**Housing Strategy and Development Team  
Housing Services  
Planning Application Comments**

**Planning Application Number: 21/02180/REM**

**Site Name: OS Parcel 9507 South Of 26 And Adjoining Fewcott Road,  
Fritwell**

**Date of Comments: 17/09/2021**

Plots 05 & 06  
Floor Plans and Elevations

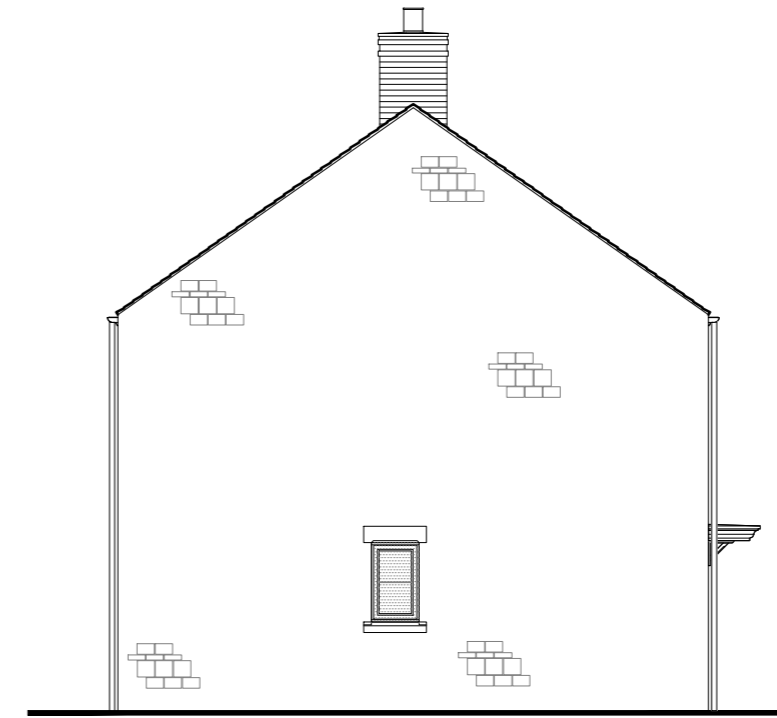
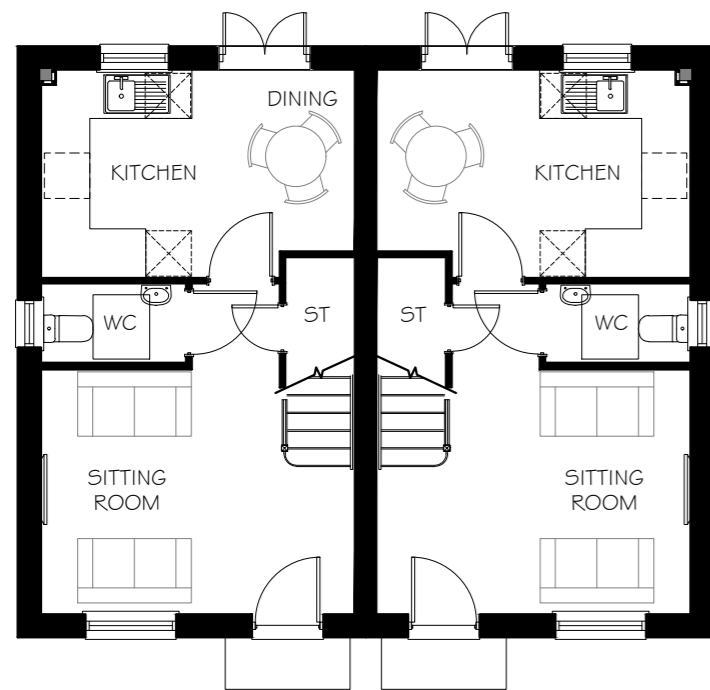
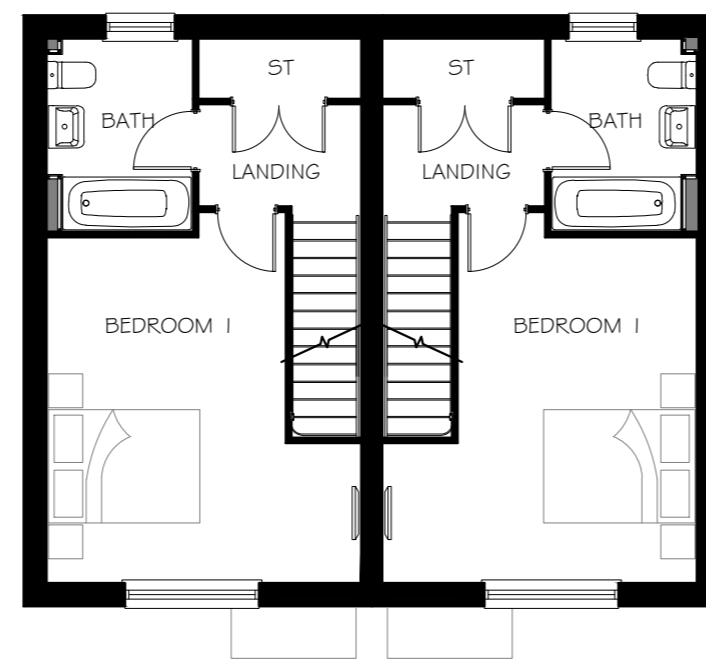
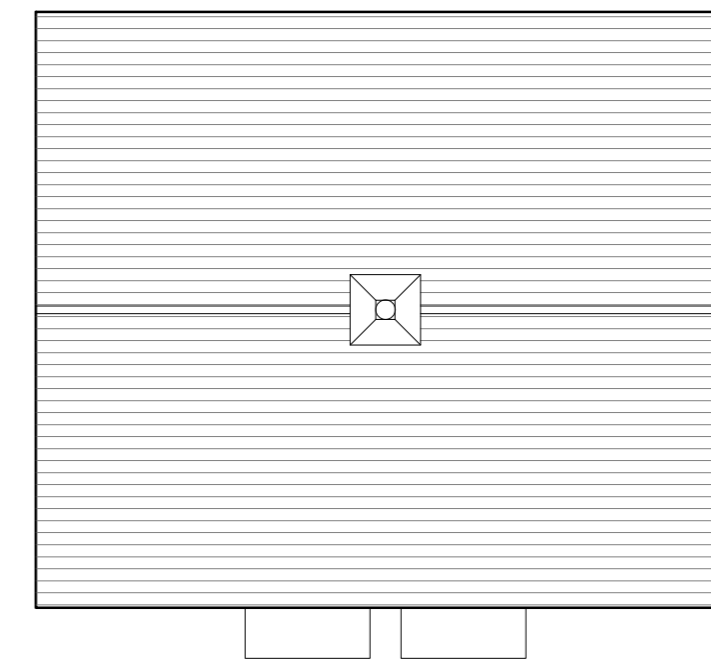
**Size Standards** - Whilst the mix of affordable housing property types meet with identified needs, it is not clear if any of the units will meet the Nationally Described Space Standards GIA measurements for 3-bedroom 5-person houses; 2-bedroom 4-person houses and 1-bedroom 2-person houses constructed over 2-storeys. The floor plan/elevation drawings provided for plots 3&4; 8&9; 10&11; 13&14; 19&20 do not show the measurements. The planning applicant will need to confirm by providing floor plans with clear dimensions and GIA calculations to show how the affordable homes meet with the required NDSS GIA size standards (NDSS is a requirement set out in the S.106).

This dwelling mix will contribute towards meeting local affordable housing need. However, as mentioned earlier the GIA sizes for each of the units will have to be clarified by the applicant and must meet the NDSS standards for the property type and required number of persons.

Plots 09, 10, 18, 19, 25 & 26
Floor Plans and Elevations

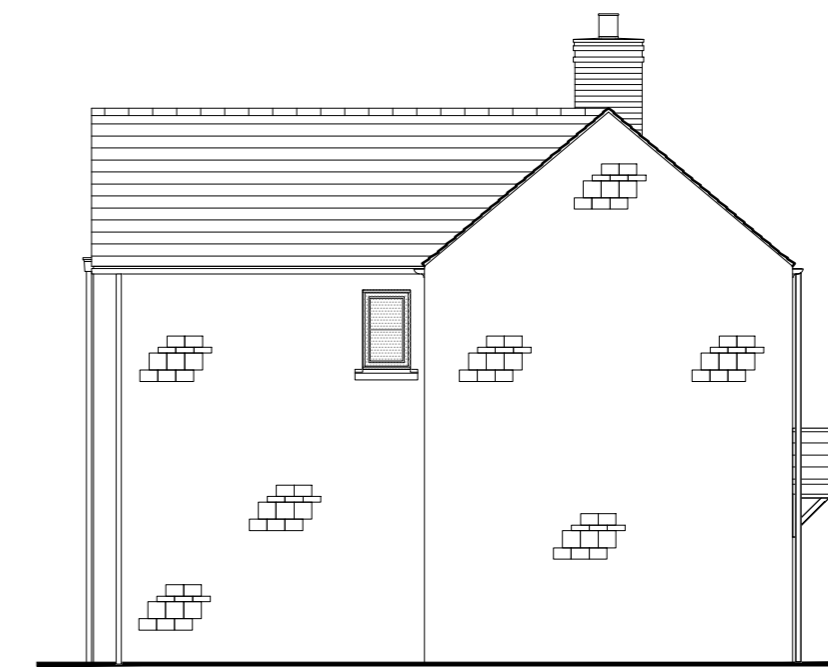
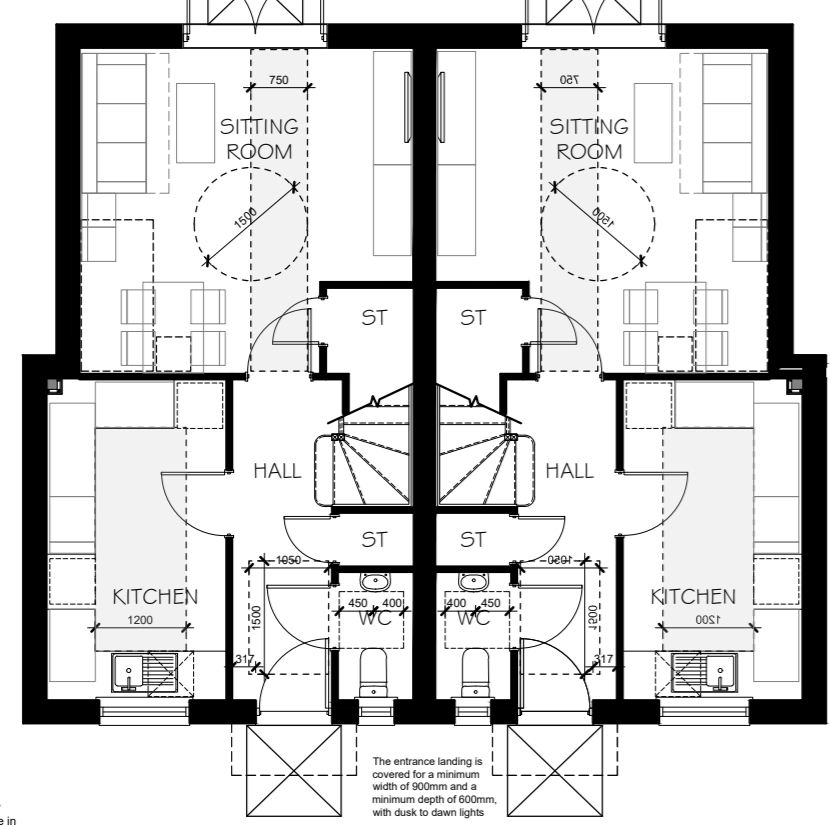
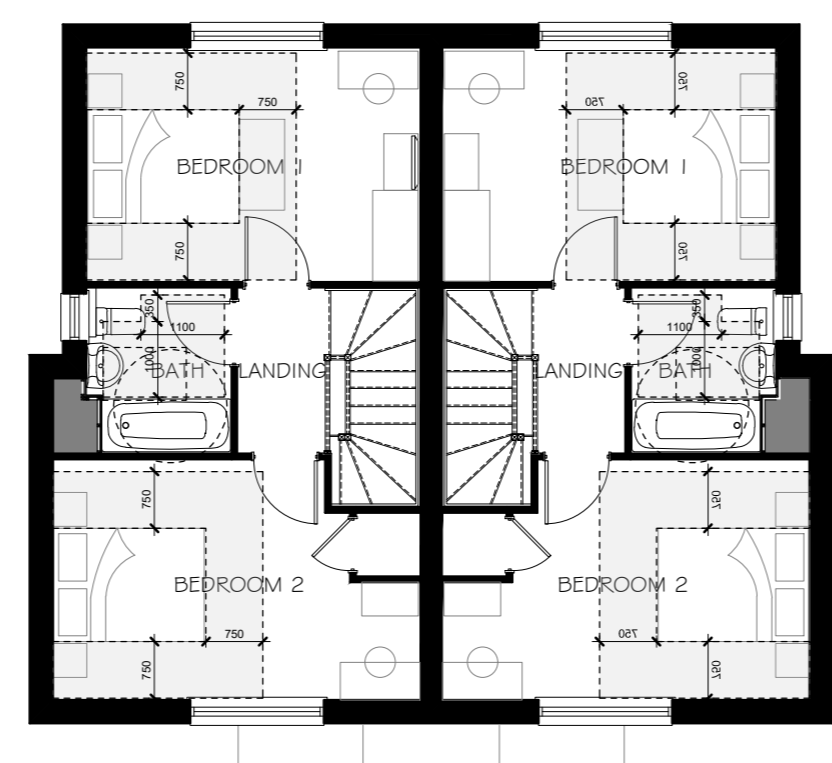
**Accessibility** – in accordance with the S.106 Agreement, 50% of the rented dwellings should be constructed to Building Regulations Part M4 (2). Whilst the legend to the floor plan drawings for the 2-bedroom houses state Part M4(2), these will need to be checked further to establish and confirm if all requirements are being met for these properties. As an observation, the return on the staircase (top and bottom) would make it difficult or more expensive to retrofit a stairlift to make the properties more accessible. Provision of rented affordable housing bungalows would have been a preferred option to meet accessible ground floor accommodation needs. The 2no. bungalows to be constructed to M4(2) standards on the site are proposed as market housing.
